**From:** Alan Taylor  
**Sent:** 10 October 2017 12:26  
**To:** planning  
**Subject:** 3/2017/0742 Planning request to Env H

**Environmental Health Consultation Response**

**Detail: Planning request 3/2017/0742**

<b>Address:</b>	<b>Longridge Road Chipping PR3 2QB</b>		
<b>Application Ref:</b>	37530	<b>Case Officer:</b>	
<b>Response Ref:</b>	/ENV/01	<b>Issue Date:</b>

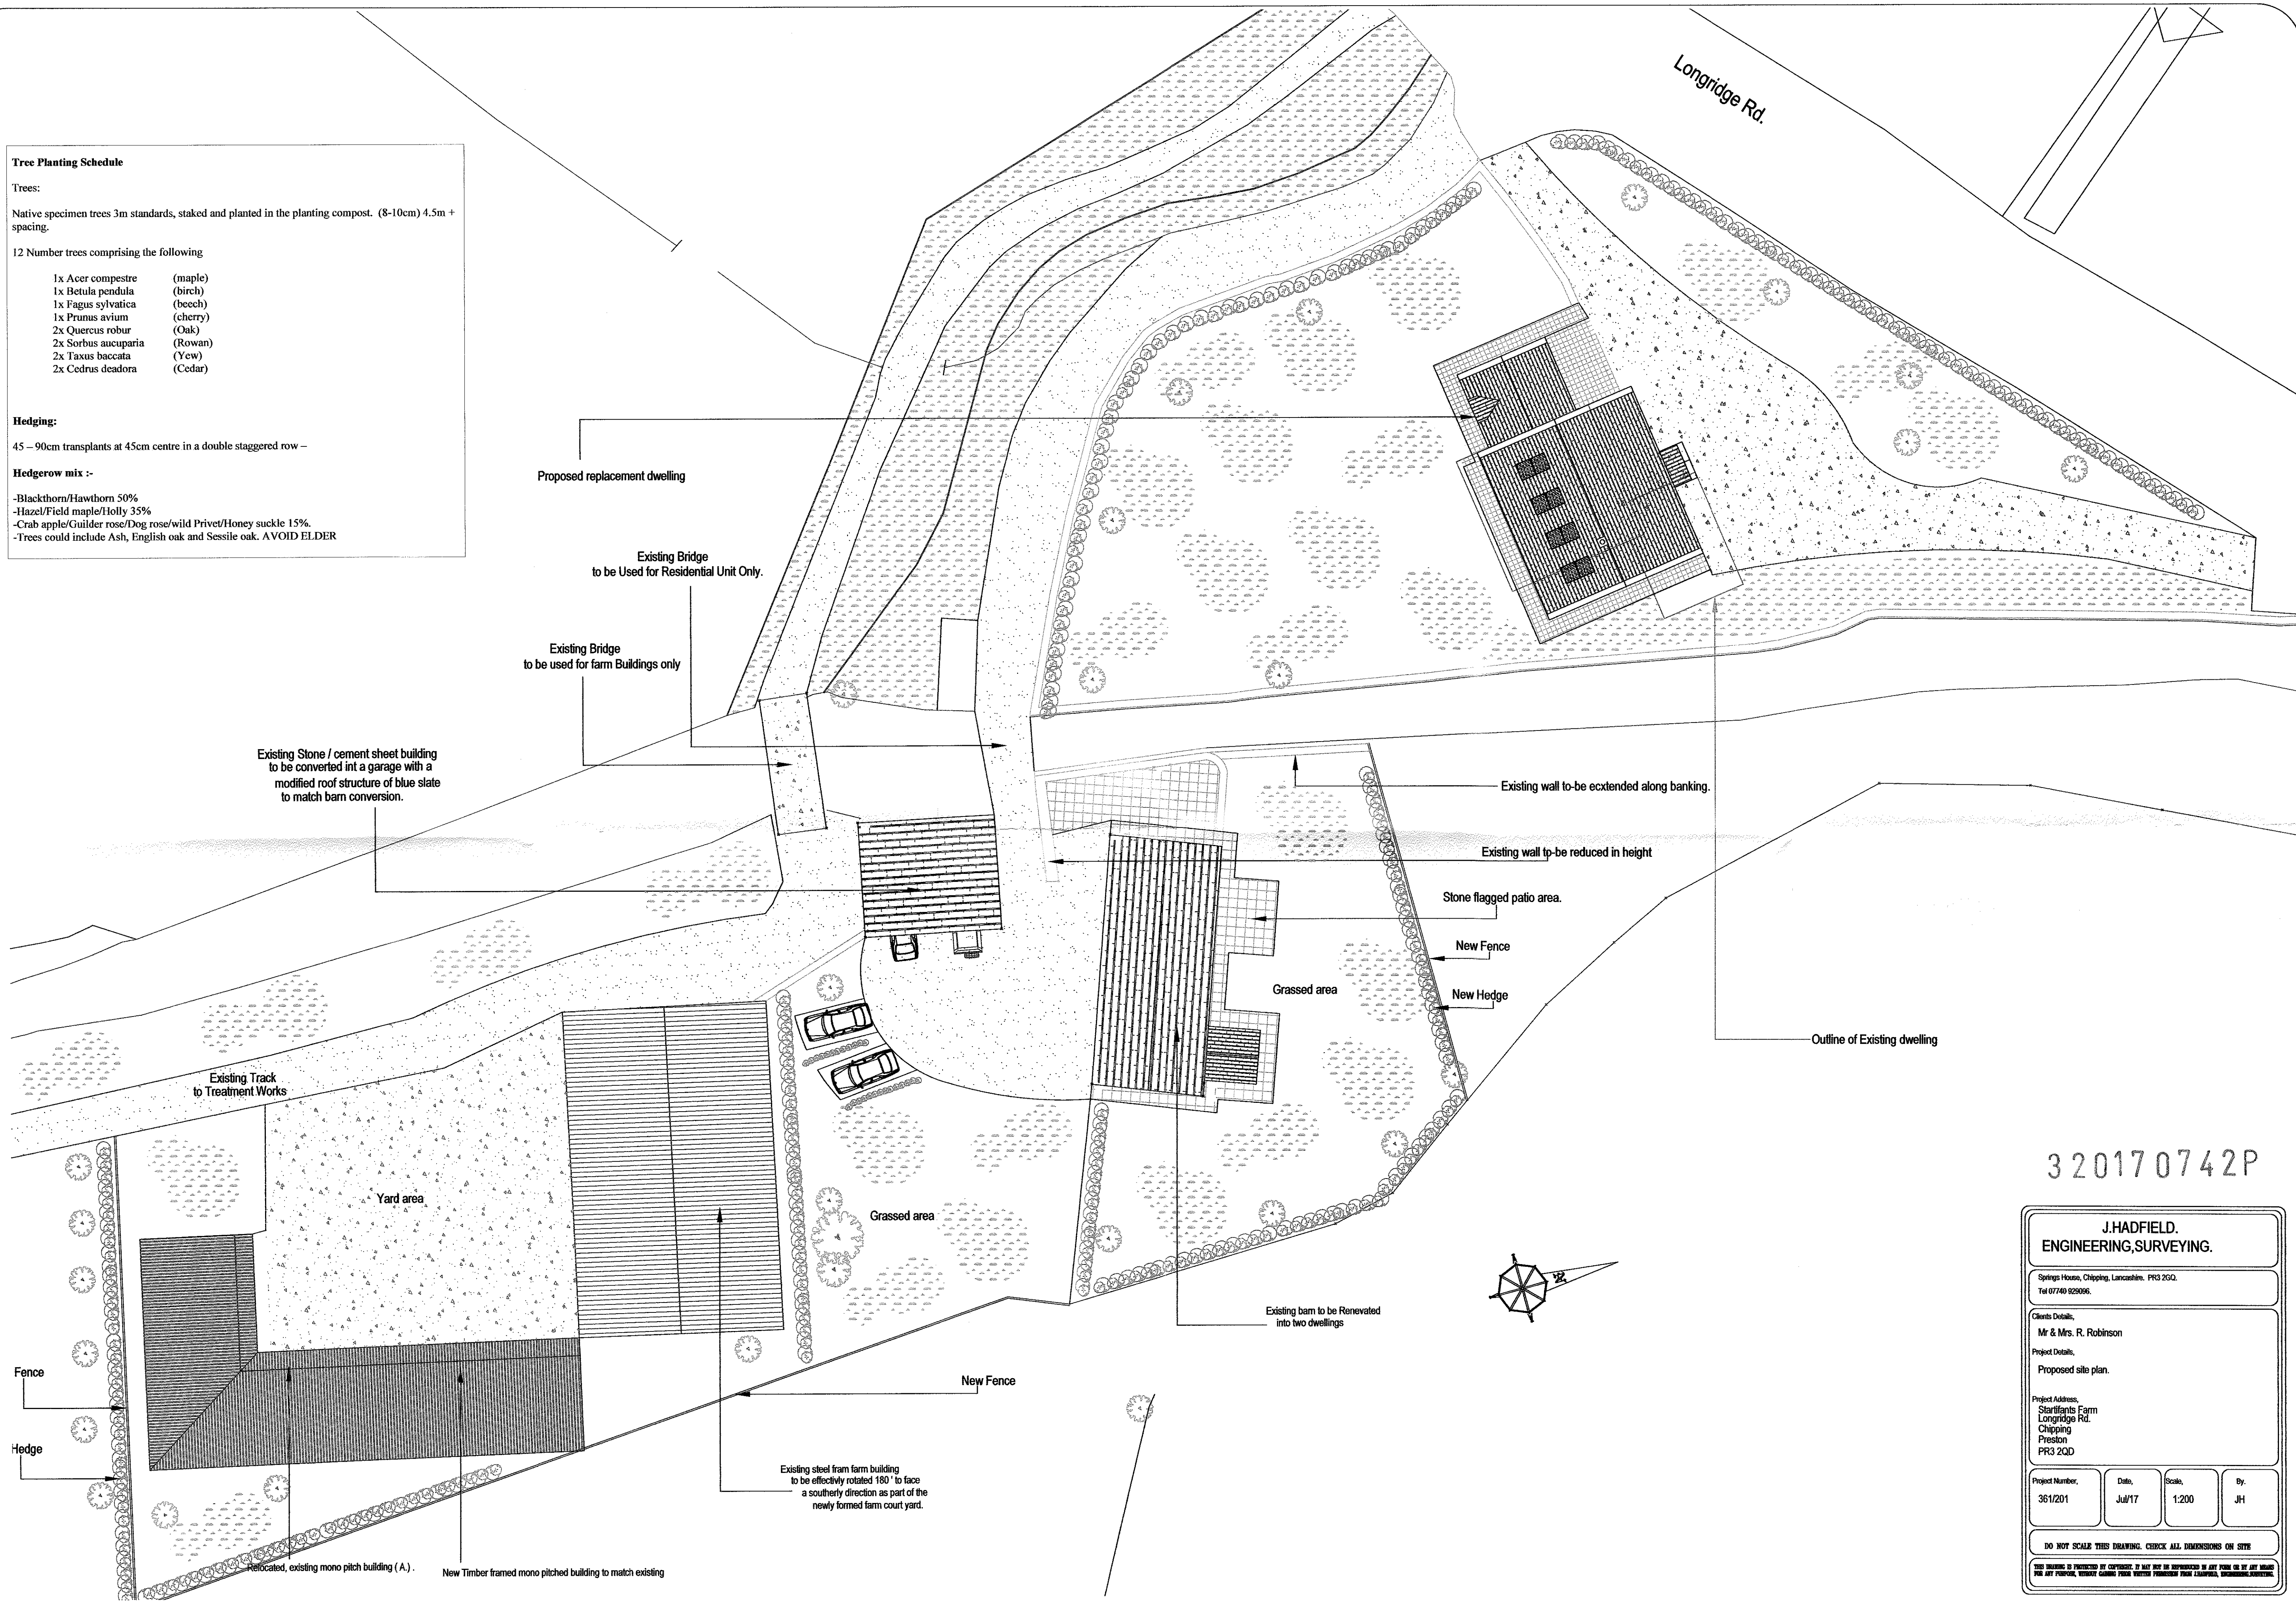
- 1.1 The planned development consist of demolition of farm buildings including a shipon and the redevelopment of new buildings including the construction of a new separate dwelling with parking space not relating to the current farm site. Concern is raised on the new layout of the farm that may have consequence for any new residents moving into the newly constructed separate residential property. Noise and odour are likely to occur on a working farm which may give rise to complaints from new residents.
- 1.2 The new developed farm buildings may also be considered for use by outside traders not residing on the farm site. This also needs to be considered as new residents to the farming community may not be prepared for the lifestyle requirements of a working farm.

- 2
- 2.1 Assessment for noise and odour needs be considered if the redeveloped site is likely to generate nuisance for any new residents moving into the new dwelling located on the original farmland.
